Fosse Green Energy Park DCO
Application by Fosse Green Energy Park Limited

POST HEARING SUBMISSIONS
ON BEHALF OF LINCOLNSHIRE COUNTY COUNCIL
AT DL3

Figure 15-4

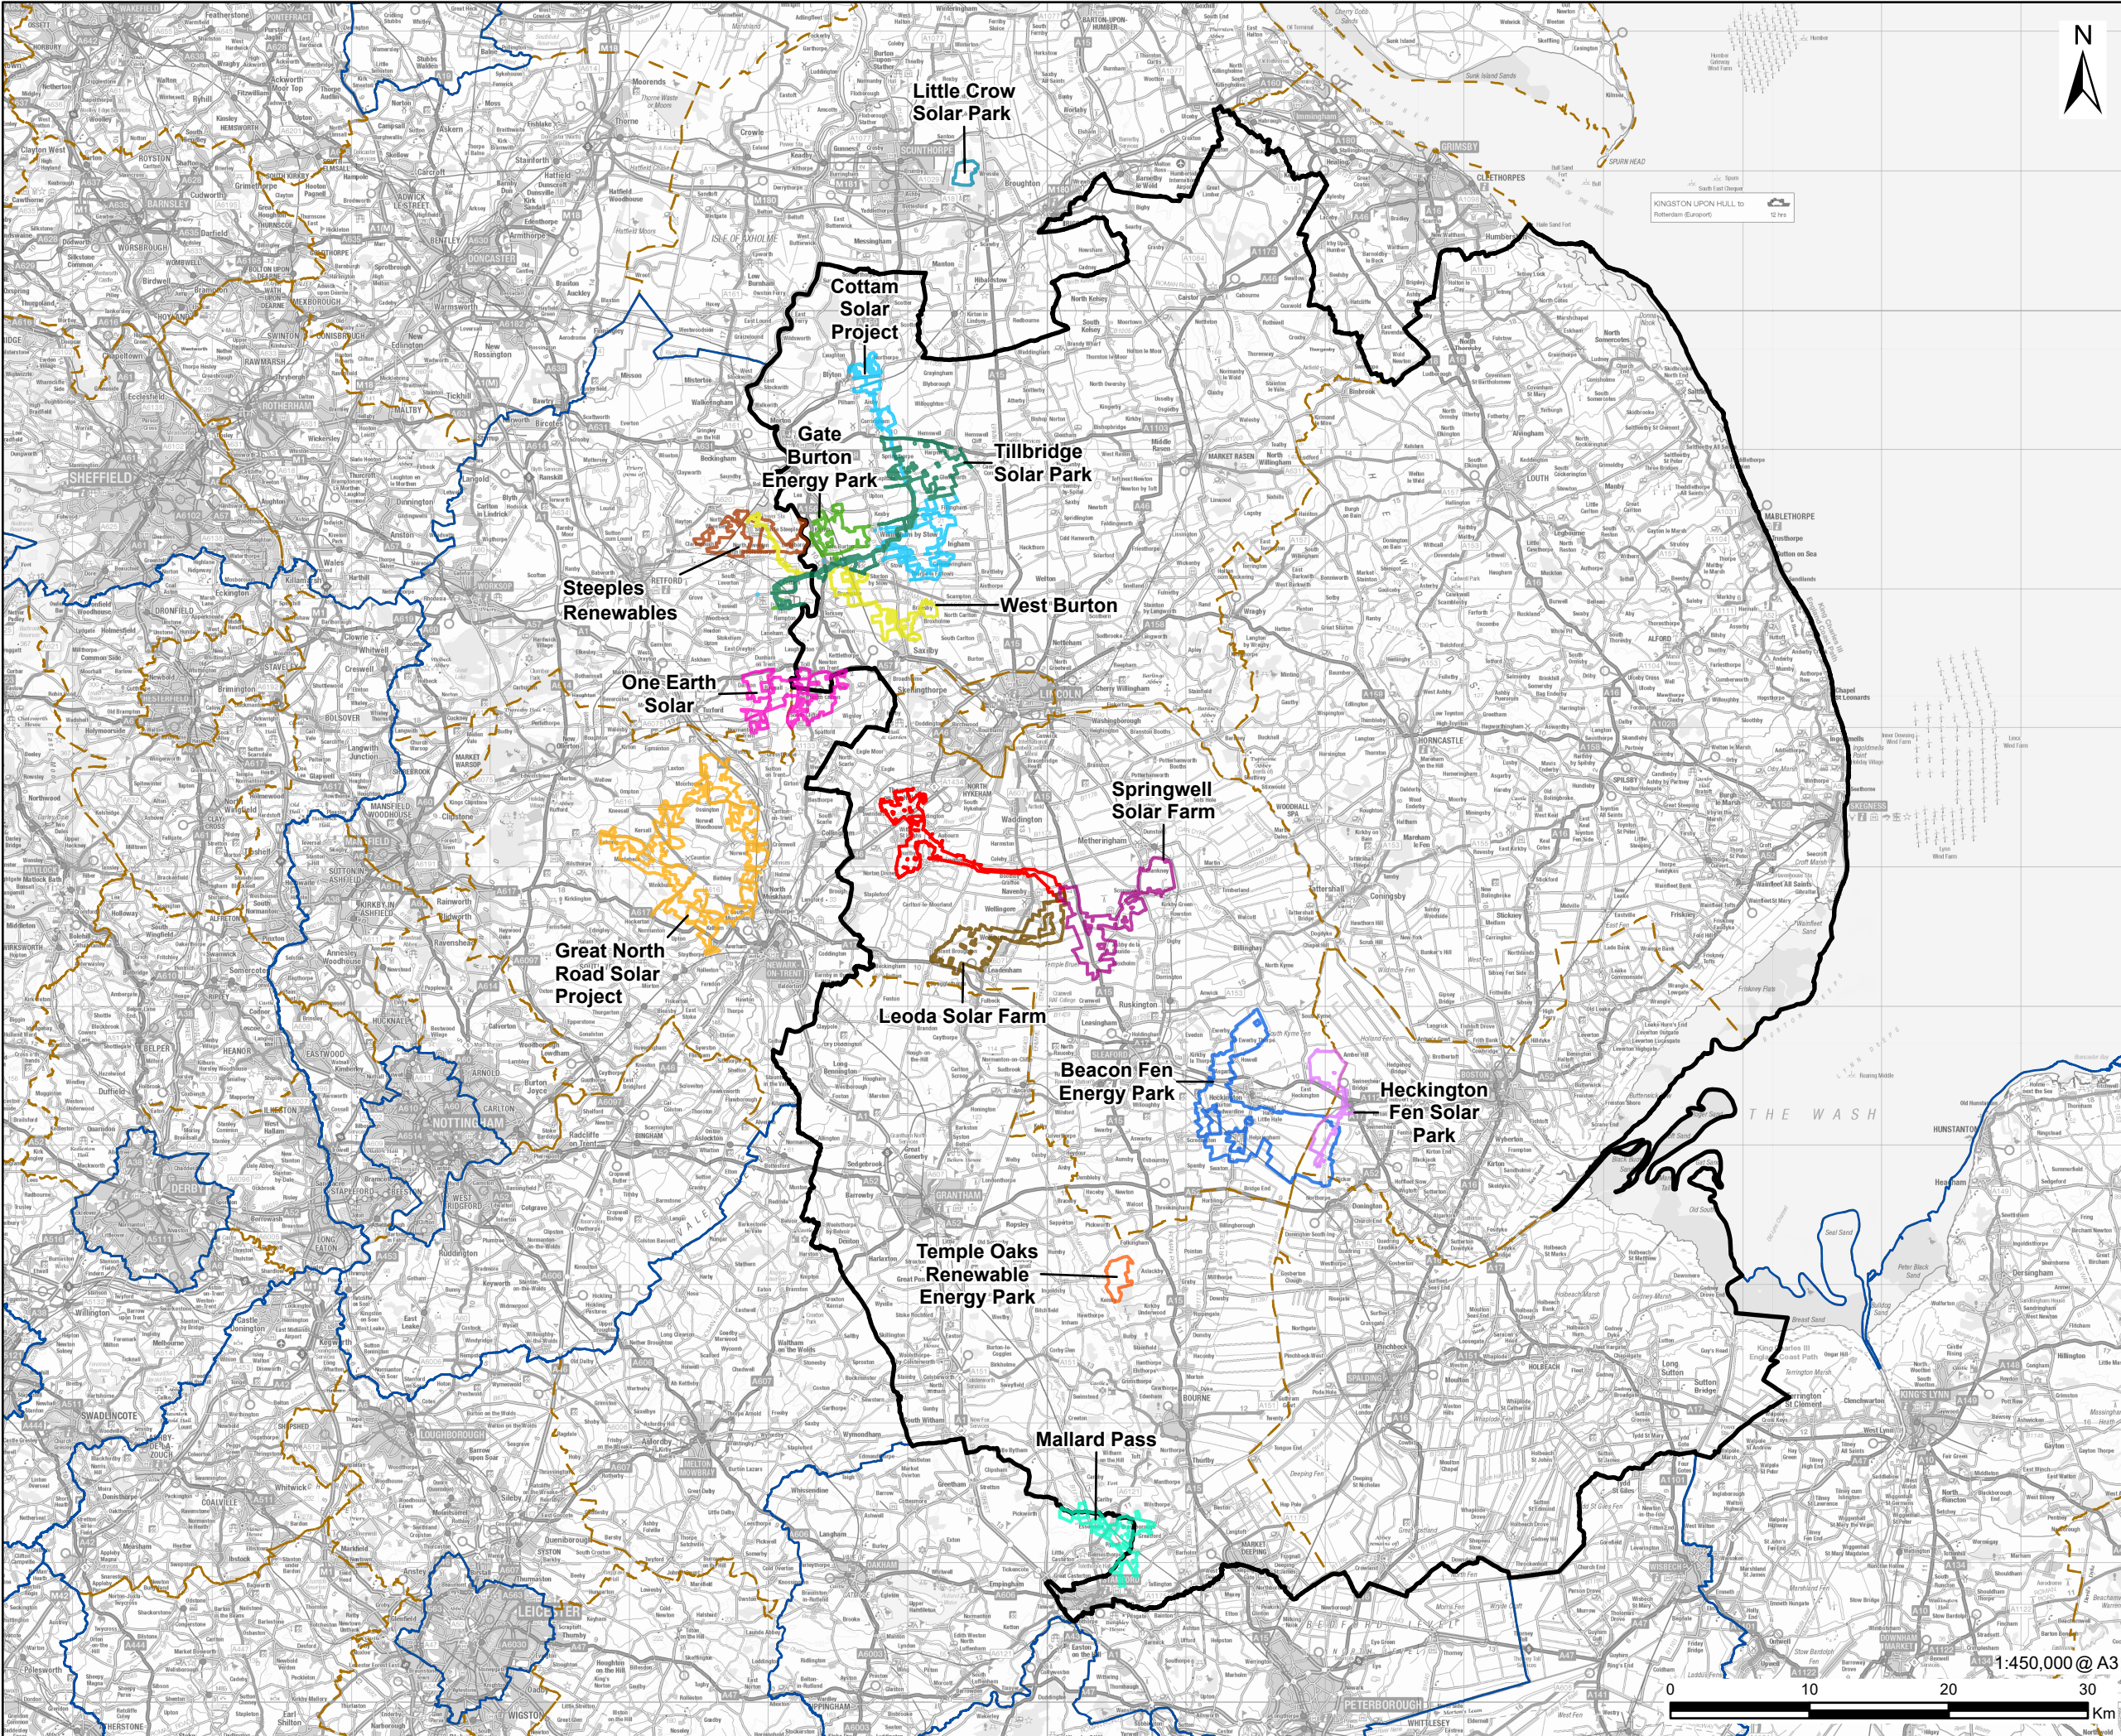
5. LCC also stated concerns regarding the cumulative impact assessment undertaken with regard to temporary workforce. As set out in the ES, the assessment does not appreciate the scale of proposed NSIP development within Lincolnshire. There are currently 25 NSIPs within the DCO approval system within the Lincolnshire County Council administrative boundary. It is highly likely that there will be overlap in construction periods, placing pressure on the availability of overnight accommodation within the county. This particular scheme will face pressure from the Eastern Green Link projects and Grimsby to Walpole overhead cable route to the East, STEP and other solar projects around Gainsborough to the North and also the Great North Road Solar project to the west, to name just a few.

9. LCC also stated that when the development is considered cumulatively with other existing and consented NSIP-scale solar projects – there will be a wider change in regional landscape character and the visual environment. Other NSIP schemes are described in Section 10-10 of the LVIA (DCO schemes – Springwell Energy Farm, Great North Road Solar Limited, One Earth Solar Farm).

21. Under agenda item 3.3 (c) LCC stated that the scale of change both from the Proposed Development and other inter-related developments in the area has been underestimated. This isn't one solar farm in isolation but one of several extremely large solar farms, all with associated substations and Battery Energy Storage Systems (BESS) that are considered as separate Development Consent Order (DCO) or Planning applications.

Figure 10-5

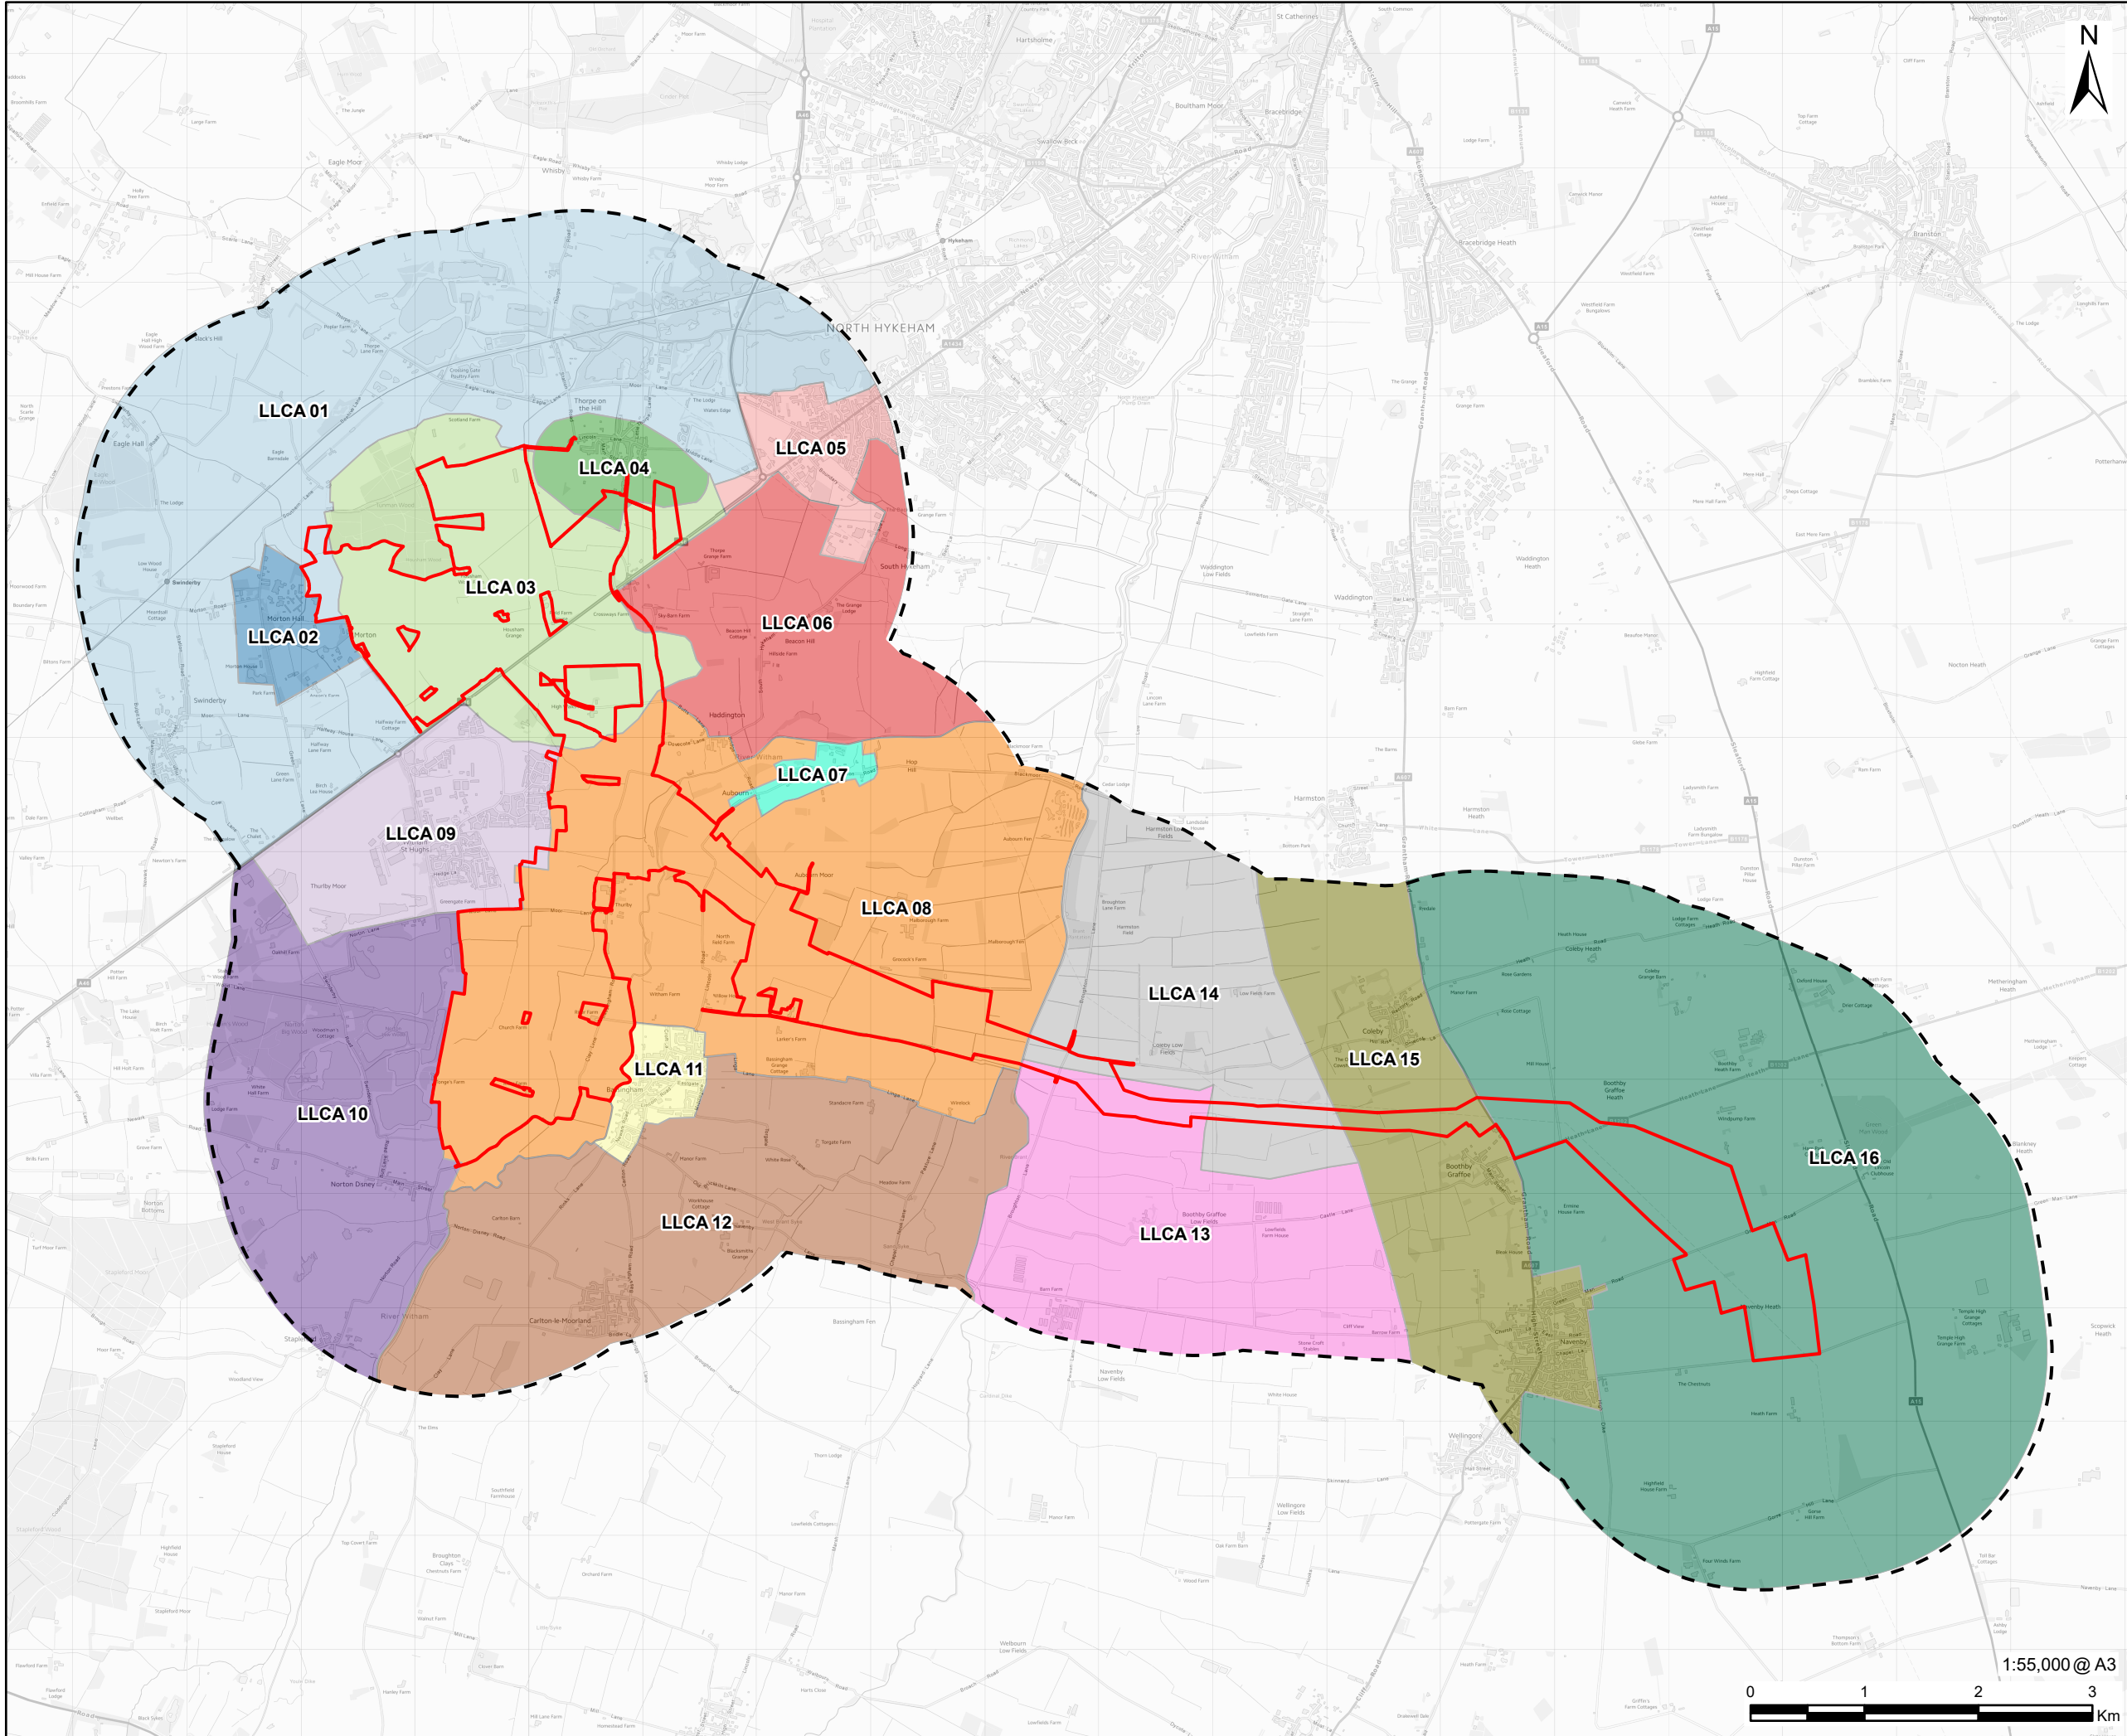
8. LCC stated that landscape receptors will experience fundamental and permanent change across an extensive area compared to the baseline. There will be inherent land use change and alteration to landscape character - not just temporary short-term change from construction activity. There will be permanent change to open agricultural character, land use, rural qualities of the landscape (seasonality) – LCC believe these perceptual factors are underplayed in the assessment. The applicant concludes Minor Adverse (non-significant effects) by year 15 for many landscape receptors (listed in Table 10-13) of ES Chapter 10 (APP-035). LCC considers that these should be classed as at least Moderate Adverse (significant).

10. LCC stated there is an over-reliance on mitigation to reduce effects. Mitigation itself could change landscape character in a way that could be adverse – through loss of openness, foreshortening, and enclosure in a landscape that is presently characterized by openness. LCC believe mitigation may reduce adverse localised effects - but it will not reduce the magnitude of the development and resultant landscape character change. Mitigation will not reinstate the open agricultural character, land use or rural qualities that define the affected landscapes.
